**RE: THE SYDNEY ZOO (SSD 7228)**

In reference to the Sydney Zoo State Significant Development Application (SSD 7228) for the new zoological facility situated at Bungarribee Park, we wish to provide the following submission.

Back of House - Elephant

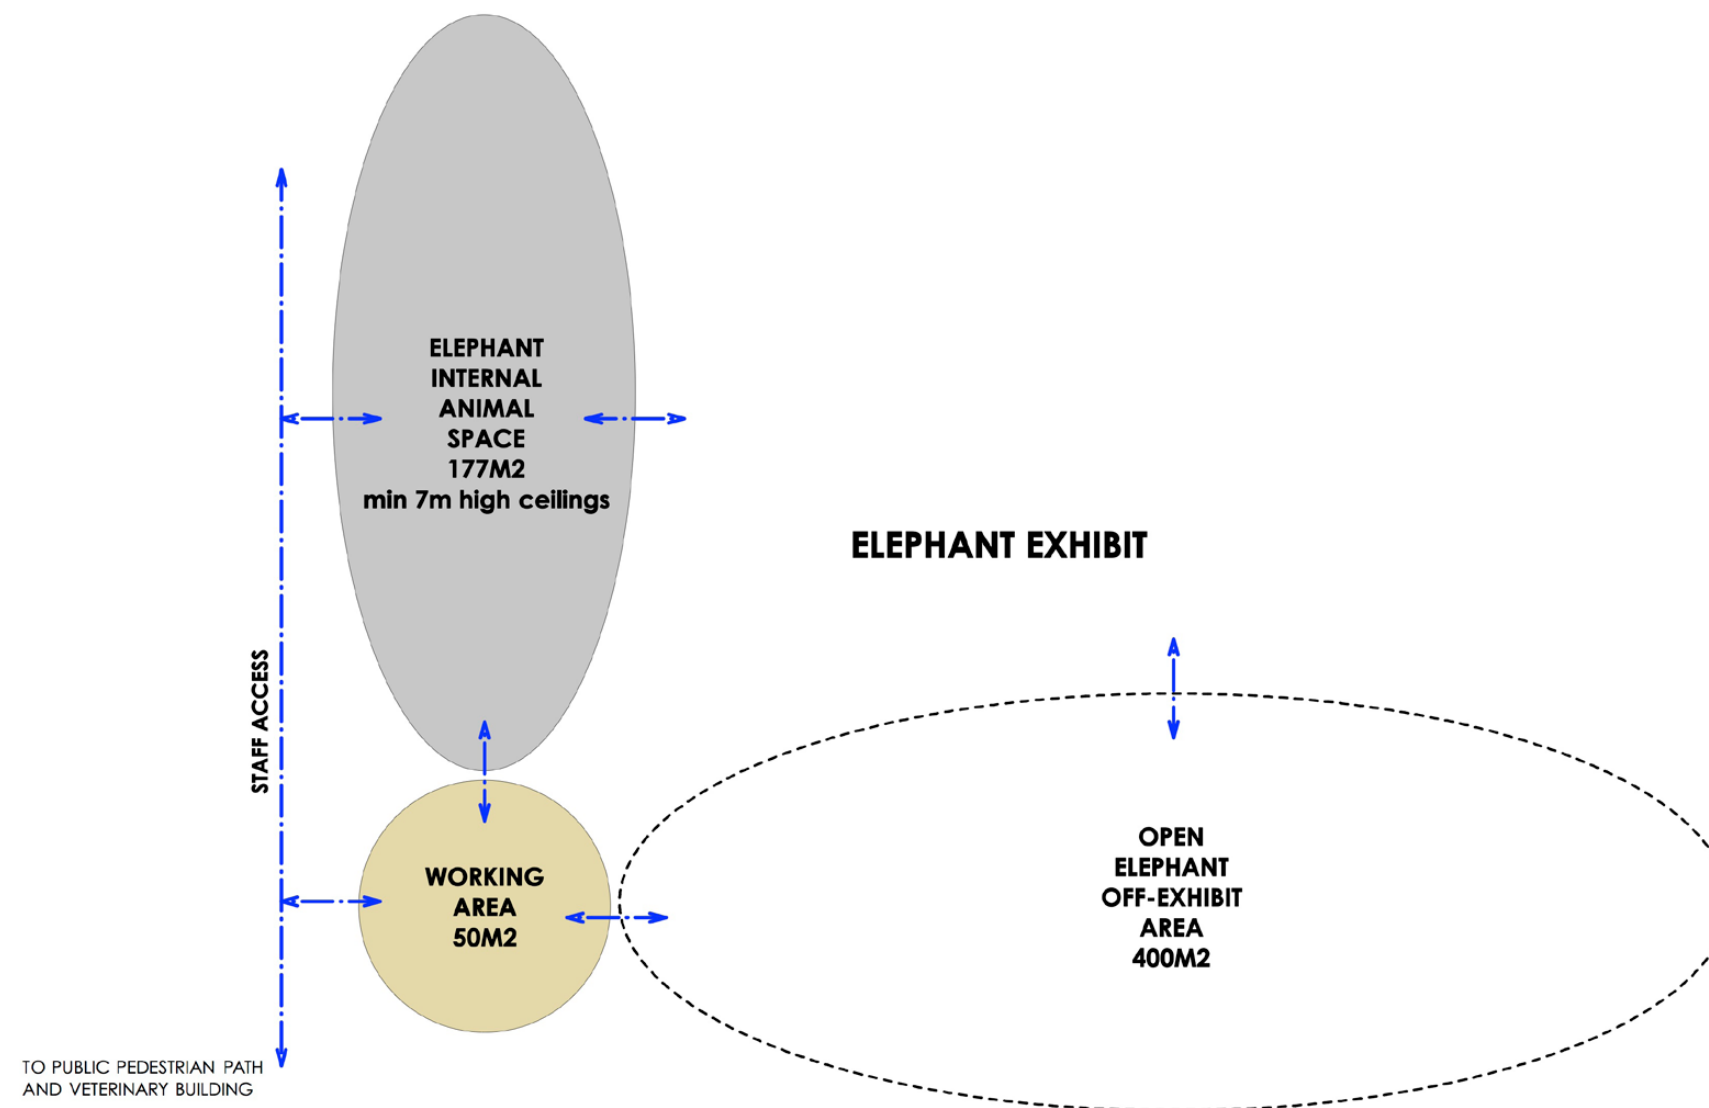
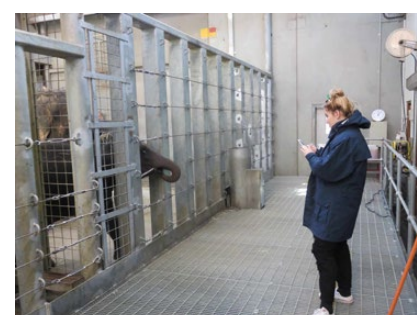
- The development application indicates provision for just 3 elephant holding stalls. Australian zoos participating in the elephant program are requested to hold male animals and a breeding herd. We therefore question whether the BOH and holding areas been designed to future proof for breeding of species that will need to be part of the regional breeding program.

- There are some conflicting spatial areas noted between BOH architectural drawings and the same areas in the BOH design principle plans.
- BOH locations need to be designed to take in consideration impact of neighbouring operations, e.g. elephants is adjacent to the car park may require separation/ more seclusion.
